From: Maria Tomalova <Maria.Tomalova@arun.gov.uk>
Sent: 03 November 2020 10:13
To: Planning.Responses <Planning.Responses@arun.gov.uk>
Subject: FW: AW/240/20/PL 17 Nyewood lane, Bognor

Please upload the below to the above application; confirmation of number of people in HMO

17 NYEWOOD
GROUND FLOOR
1:50 SCALE

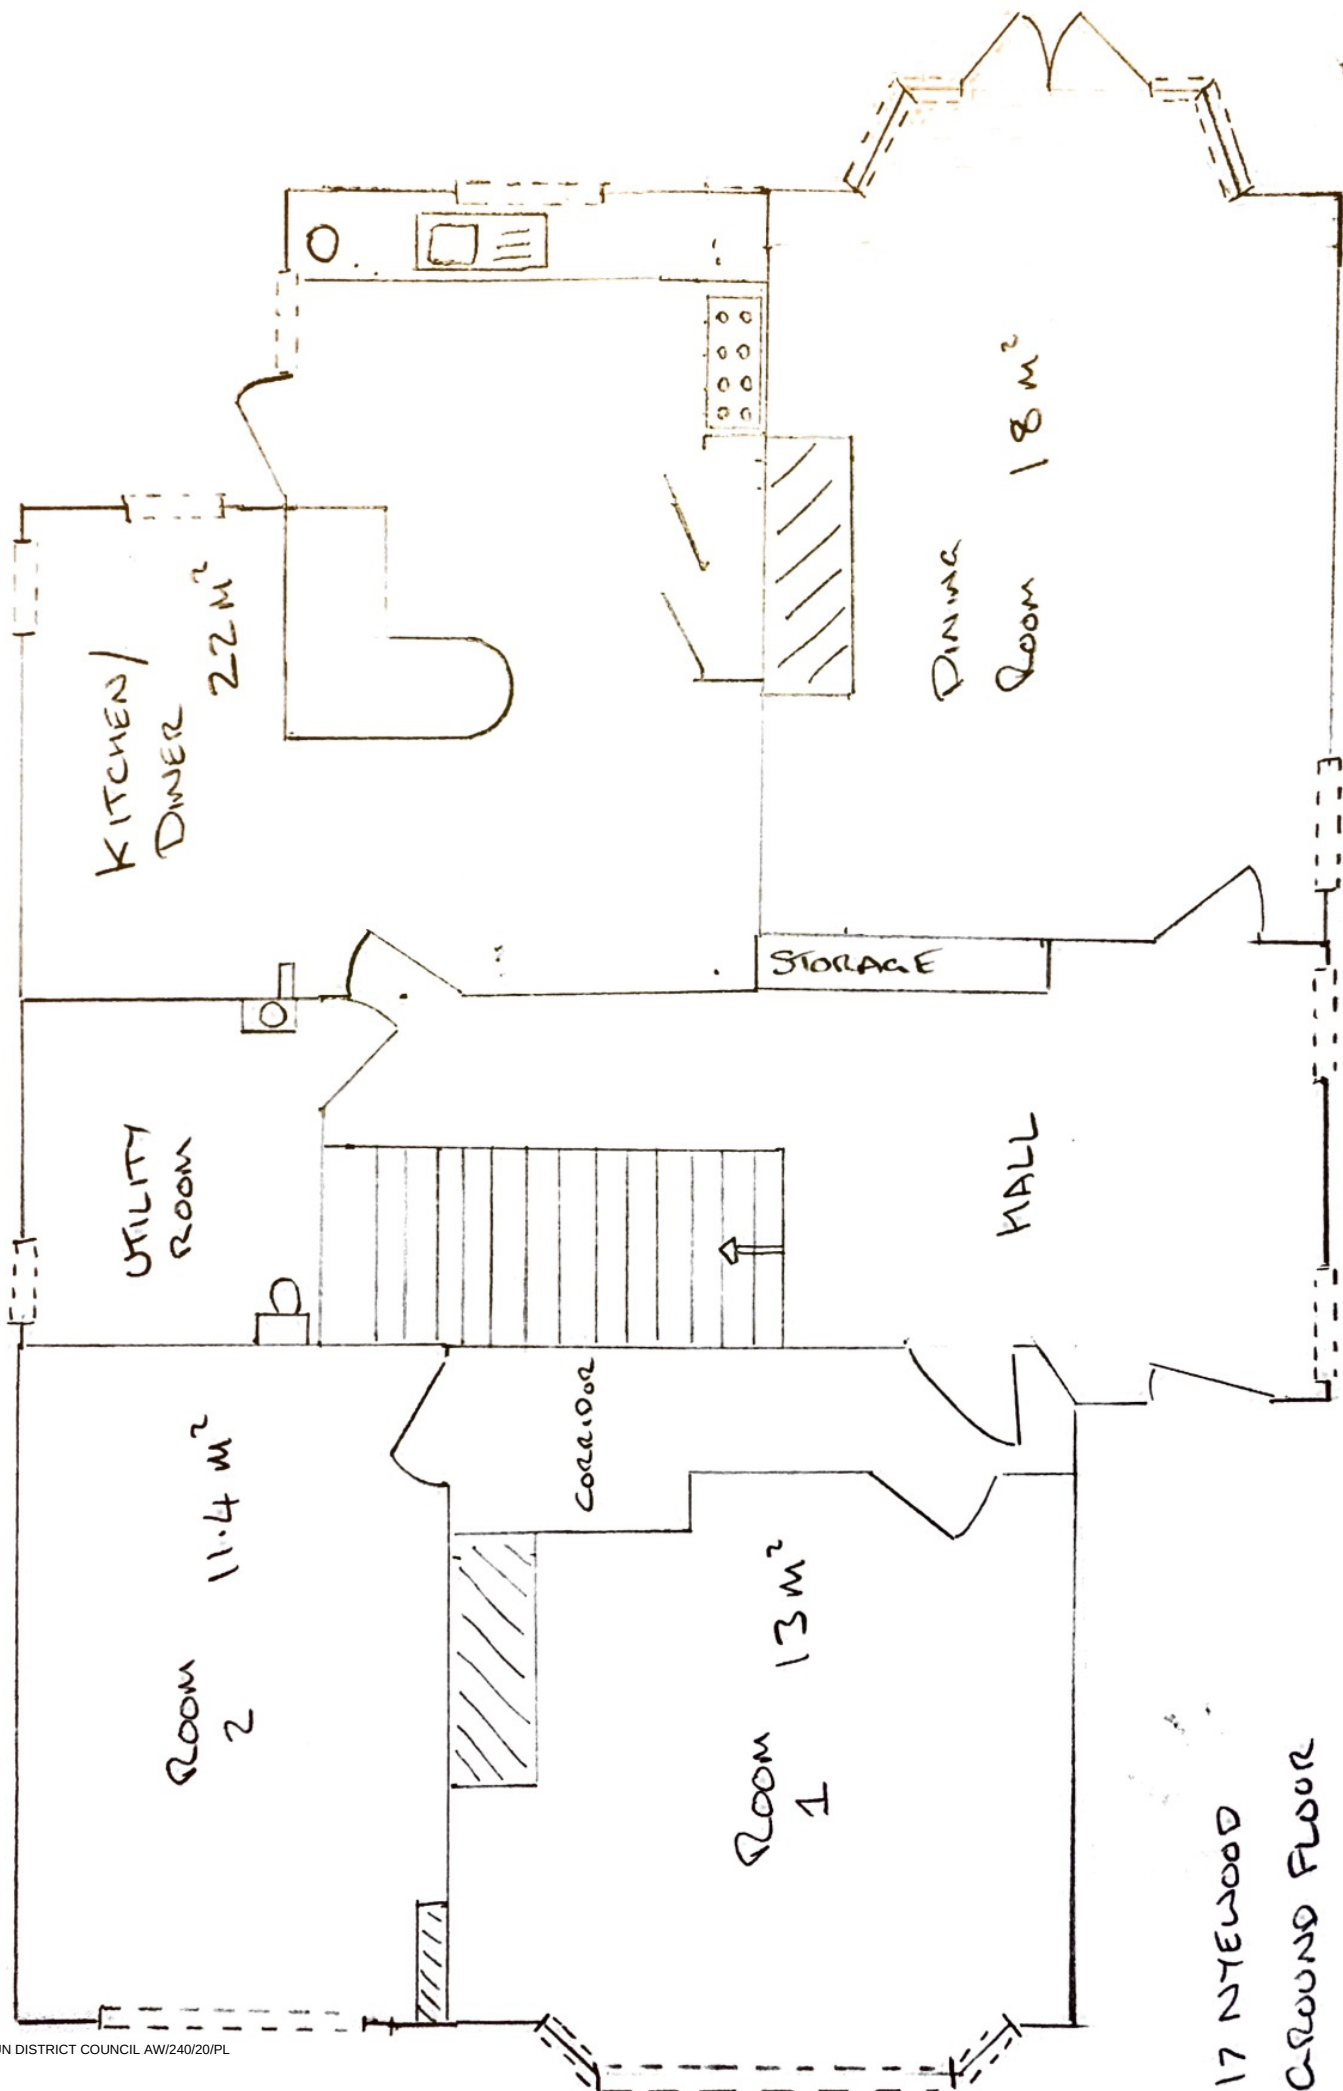
I have checked again your plans; I can't see any problem it is drawn by hand whilst it is to scale. I would argue the room 4 is 7.7 sq metres but slightly less.
